SE-16-00001

SEPA ENVIRONMENTAL CHECKLIST

1. Name of proposed project, if applicable: [\[help\]](#) Improve Existing road to Kittitas County Private Road Standards
2. Name of applicant: [\[help\]](#) R&R Heights Land Co.

| SHEET    | C2.0      |

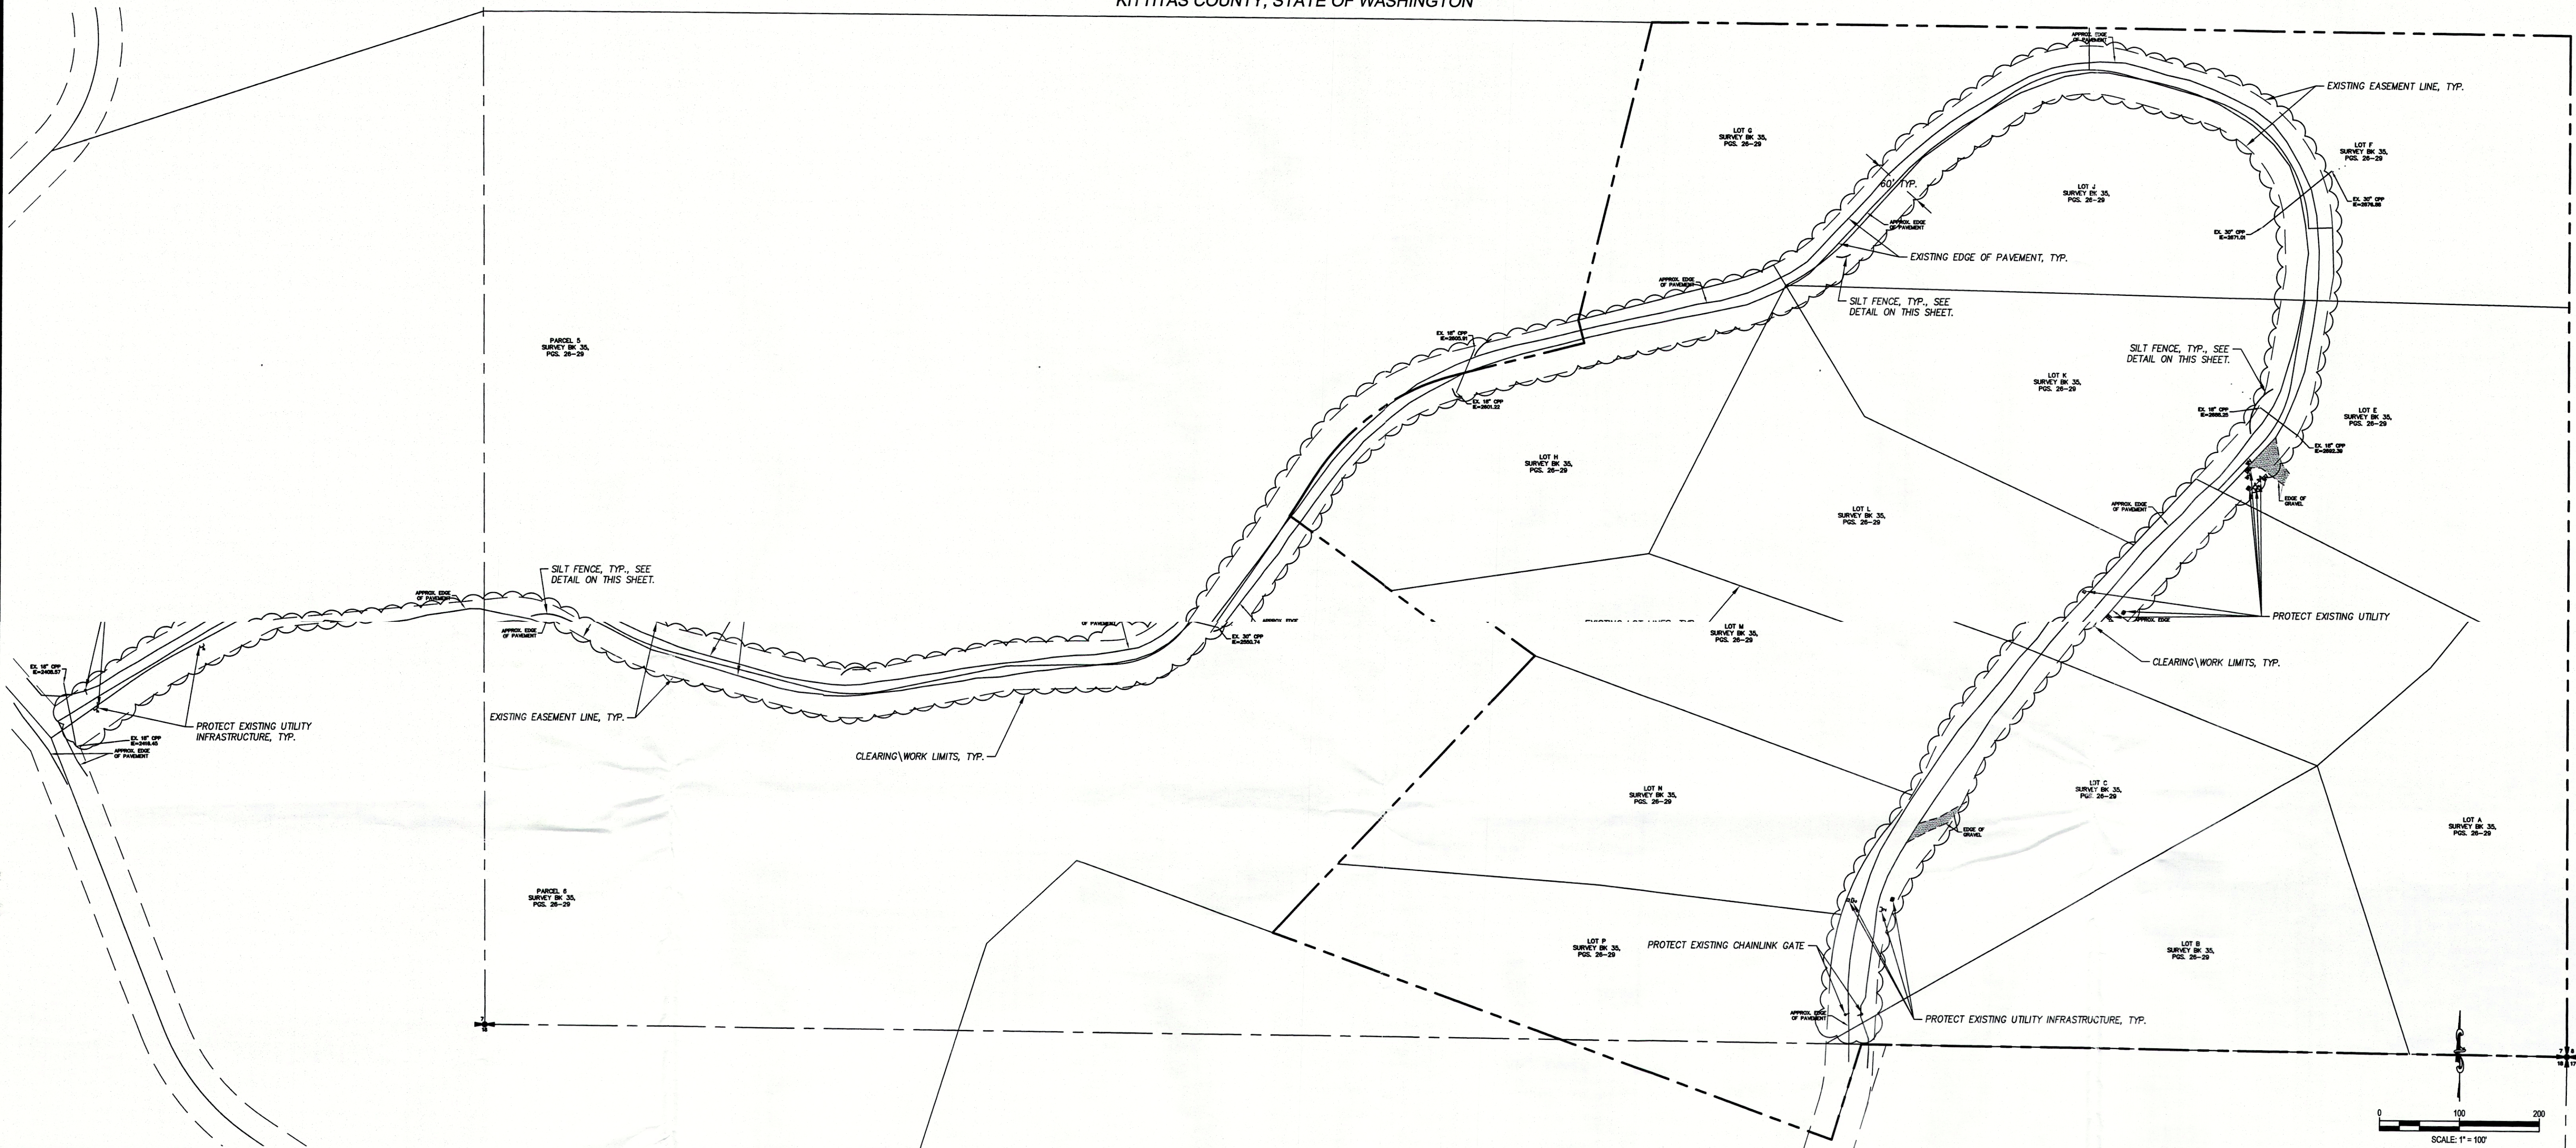
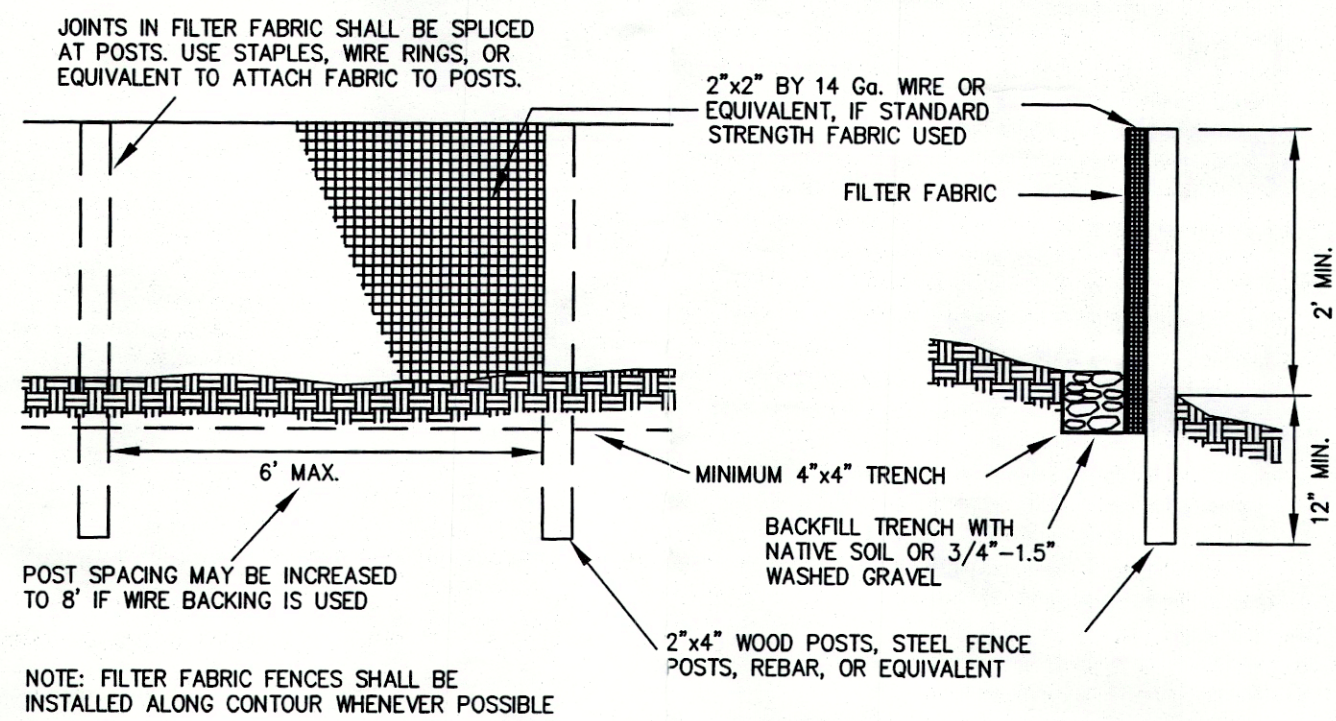
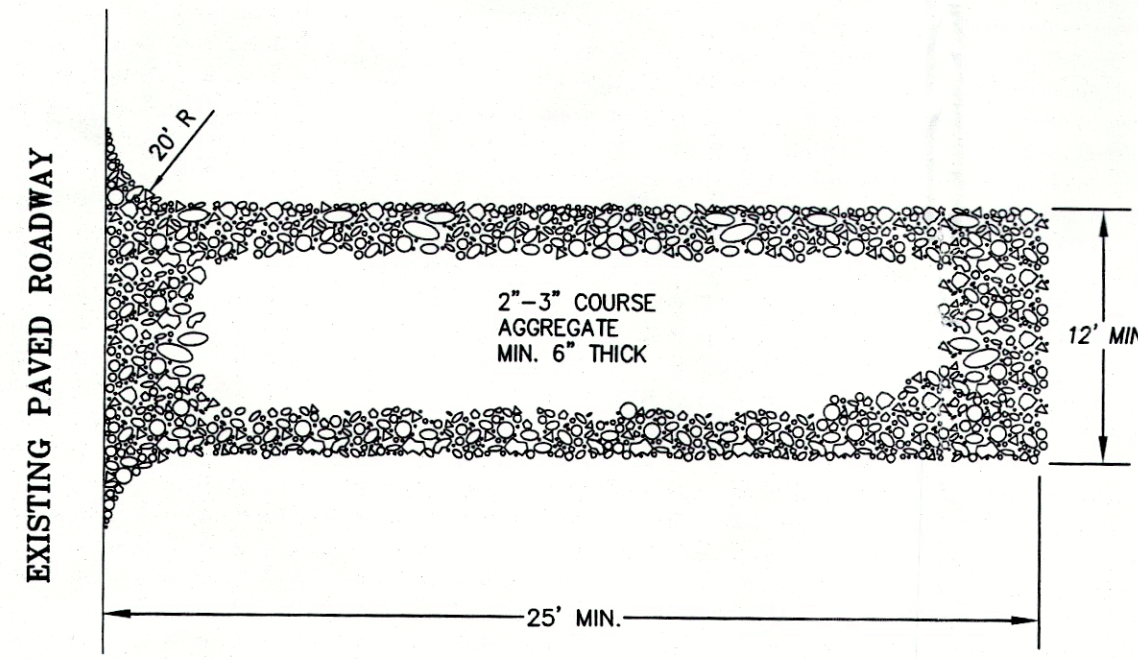
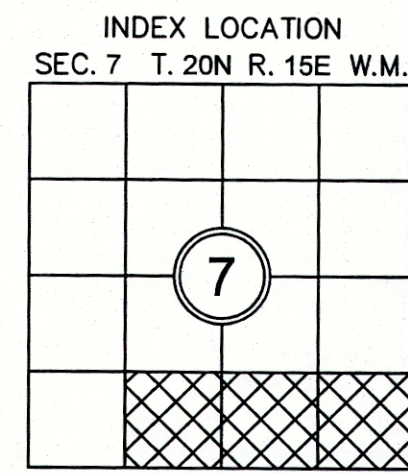
← WHAT WILL BE CONSID. EROSION "APPROPRIATE" OR "PROPER" FOR EROSION CONTROL?

← WATER TRUCKS USUALLY ARE USED ~~OVER~~ EVERY X PERIOD

← WE CAN'T DO THIS W/O PLANS,
